Our Case Number: ACP-322845-25

An
Coimisiún
Pleanála

Date: 02 April 2026

Re: Proposed development of 11 wind turbines and ancillary development within the townlands of Ballynamullagh, Kilmurry, Coolree, Killyon, Mulgeeth and Drehid, County Kildare (www.drehidwindfarmSID.ie)

PROJECT		CLIENT		
<b>DREHID WIND FARM &amp; SUBSTATION</b>		<b>NORTH KILDARE WIND FARM Ltd.</b>		
SHEET	<b>T8, T9, &amp; T10 PILED TURBINE FOUNDATION DETAIL</b>	Date	Project number	Scale (@ A1-) As Shown
		11.03.25	P22-242	
		Drawn by	Drawing Number	Rev
		CS	P22-242-0300-0014	A
		Checked by		
		BC

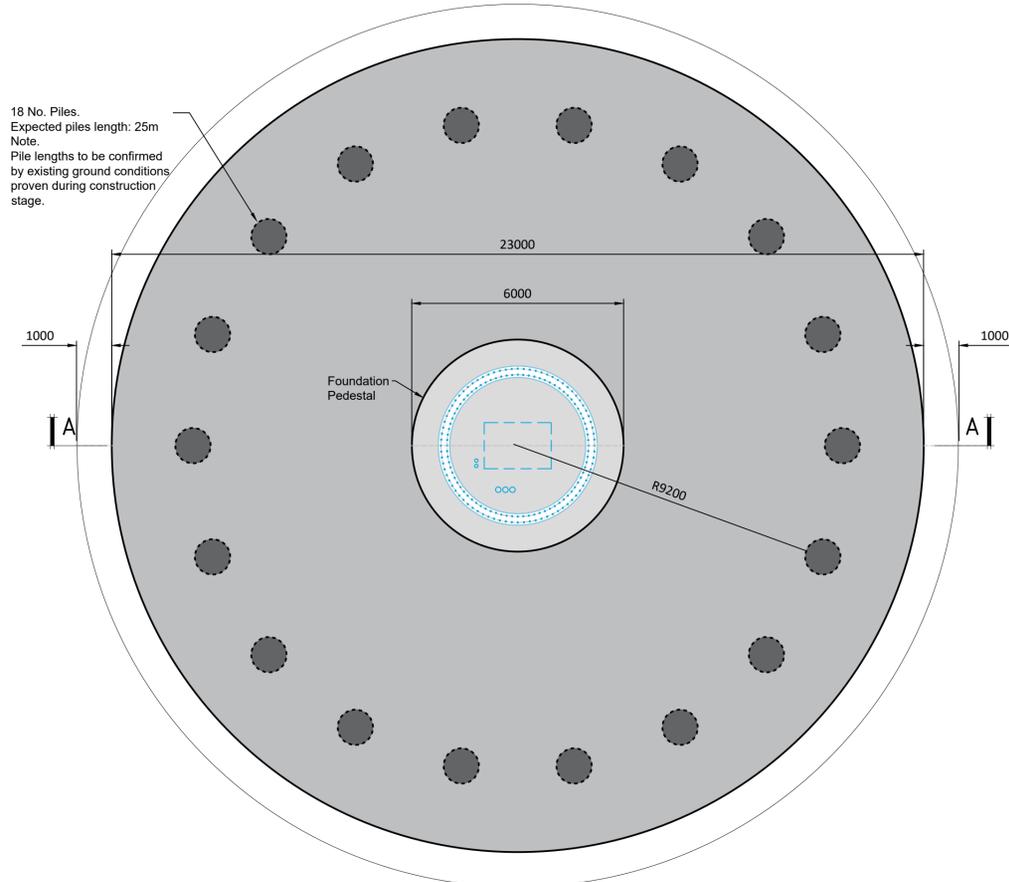
- (d) You are requested to provide an ecohydrological assessment on the potential impacts from the construction turbines T8, T9 and T10 on the hydrological functioning of the proximal Annex I habitat PB1 Raised Bog habitat, specifically Mulgeeth Bog.

TITLE:	Breeding Wader Survey Locations		
PROJECT:	Drehid Wind Farm and Substation		
FIGURE NO.:	2.3		
CLIENT:	North Kildare Wind Farm Ltd.		
SCALE:	1:22,500	REVISION:	0
DATE:	15/05/2025	PAGE SIZE:	A3

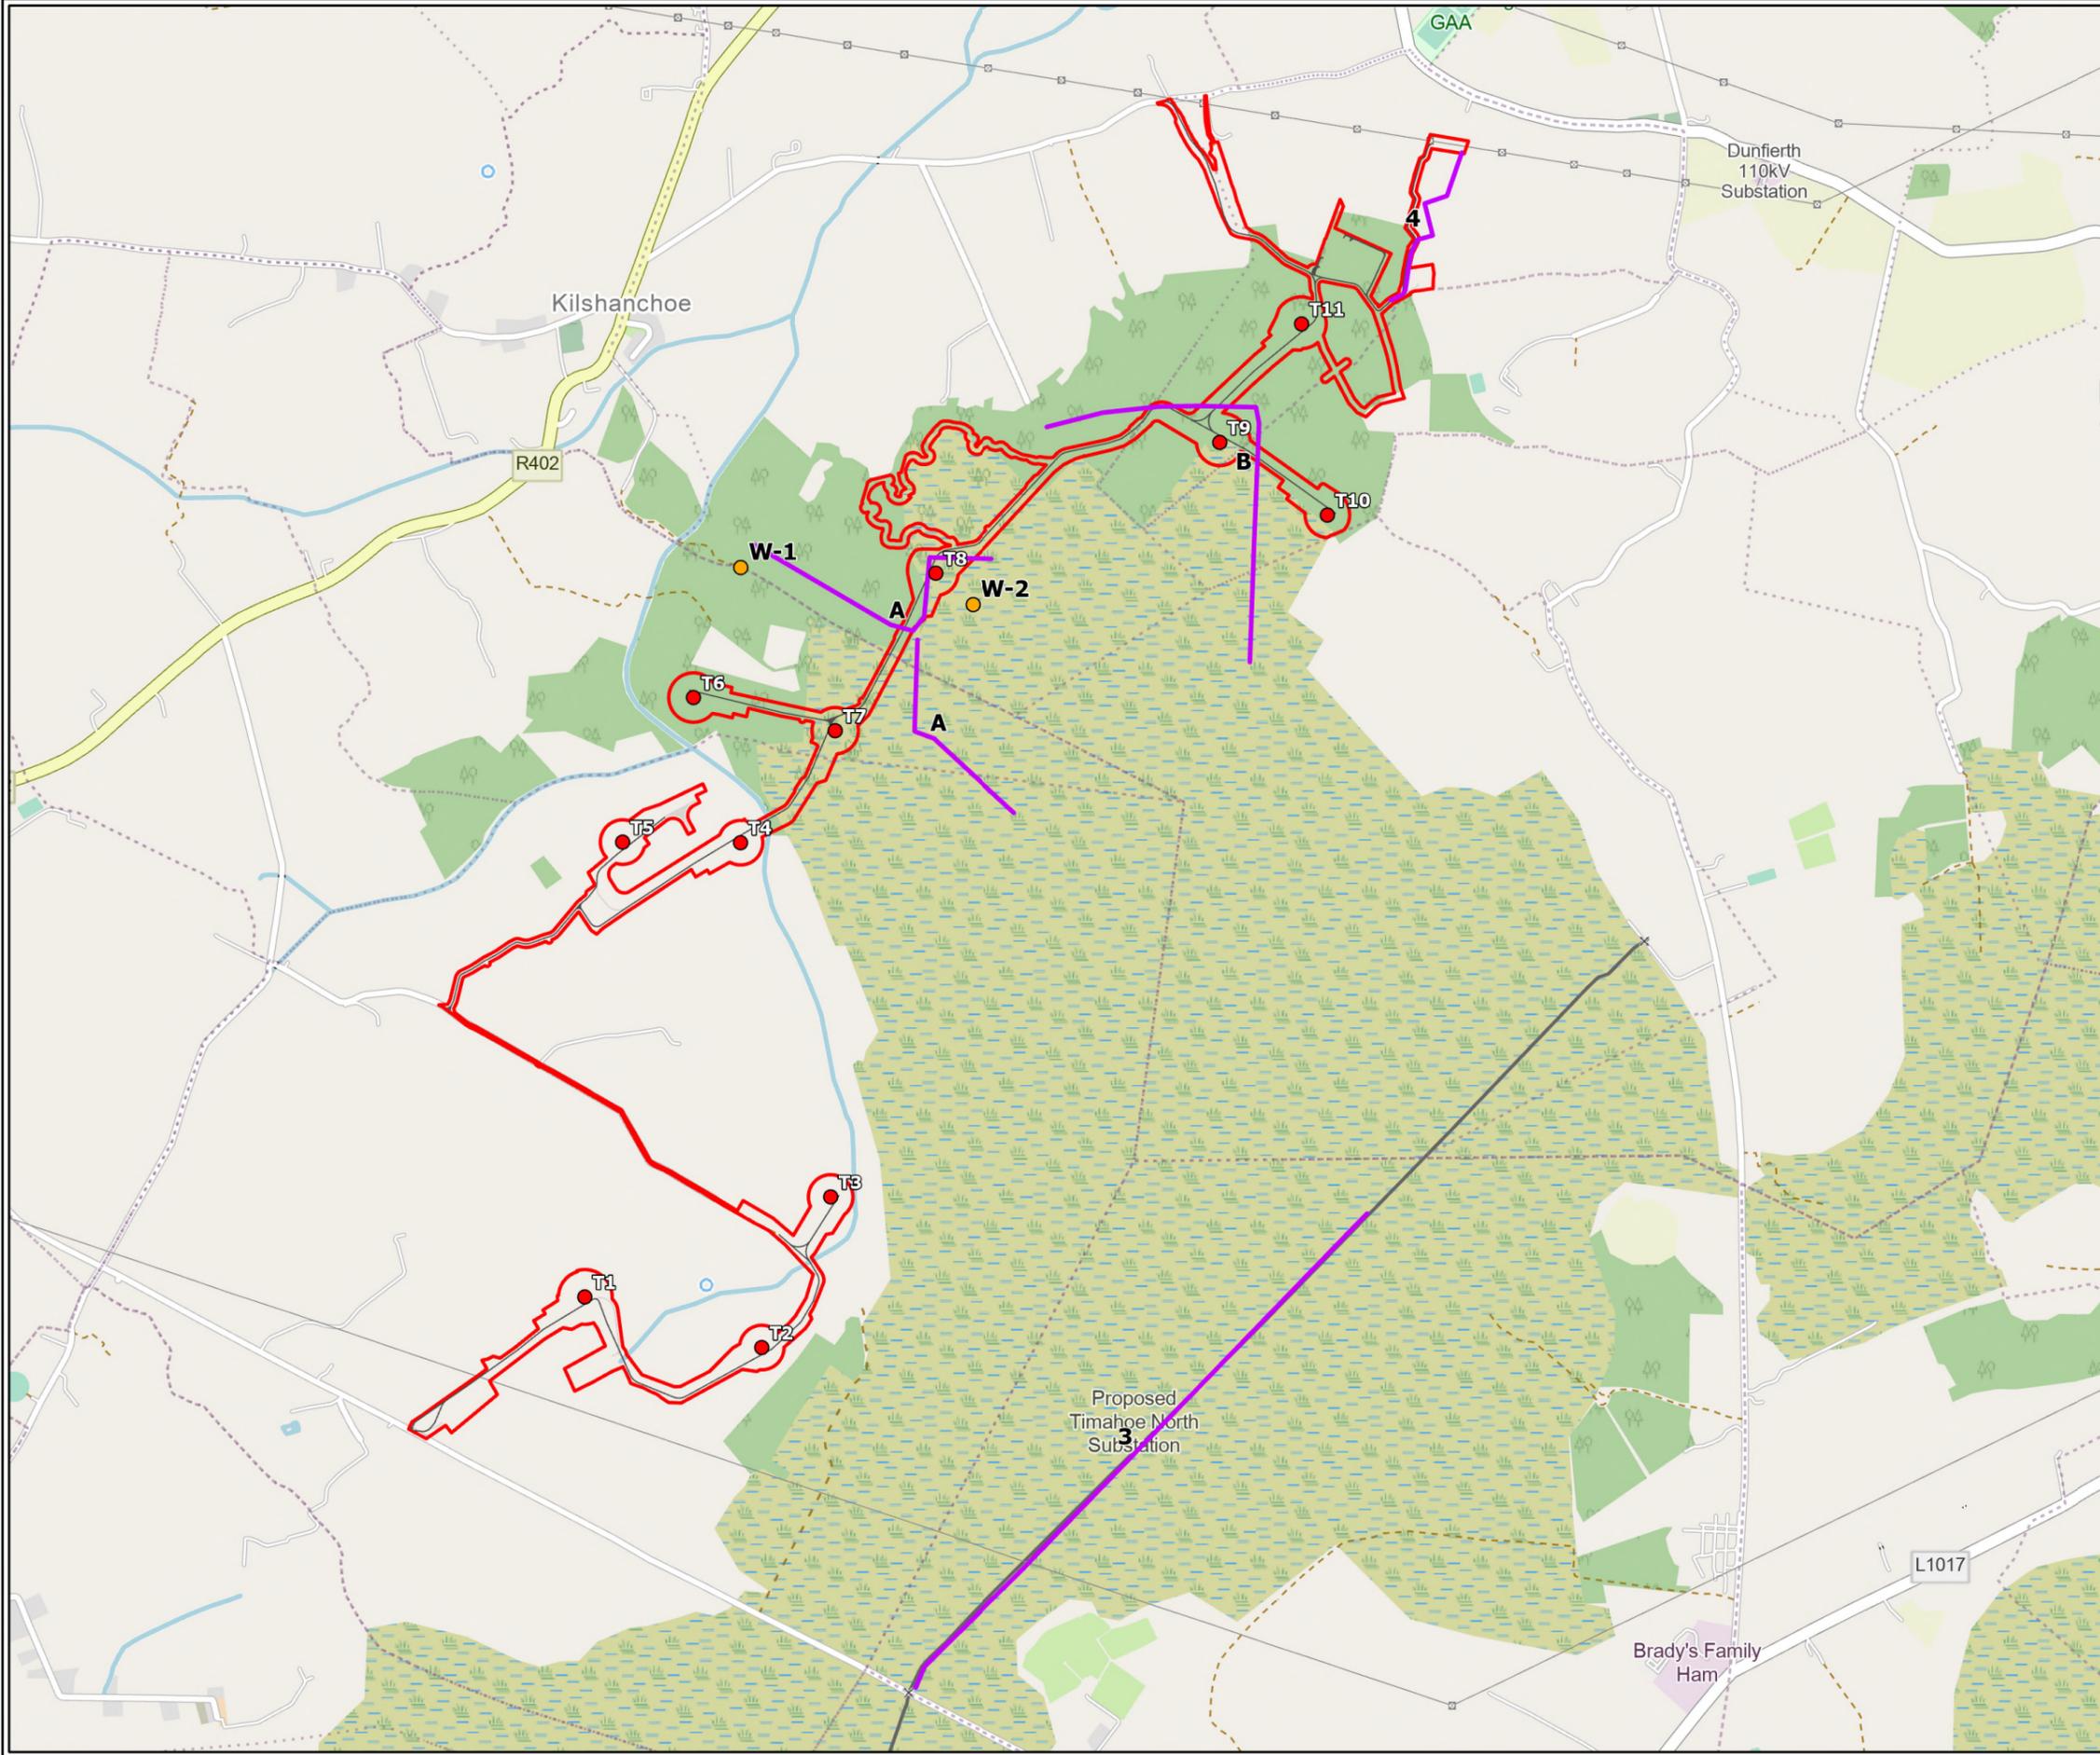
- ii. An Coimisiún Pleanála shares the concerns of the Department of Housing Local Government and Heritage, Development Applications Unit in their submission dated **14th August 2025**, relating to the absence of rationale for the selection of transects for breeding waders. The Commission also has concerns relating to the variability in survey effort during the survey period. Please provide reasoning to support your rationale and to update the breeding bird survey transects to ensure survey effort is compliant with best practice and representative of the diversity of habitats across the site and bird species associated with same.
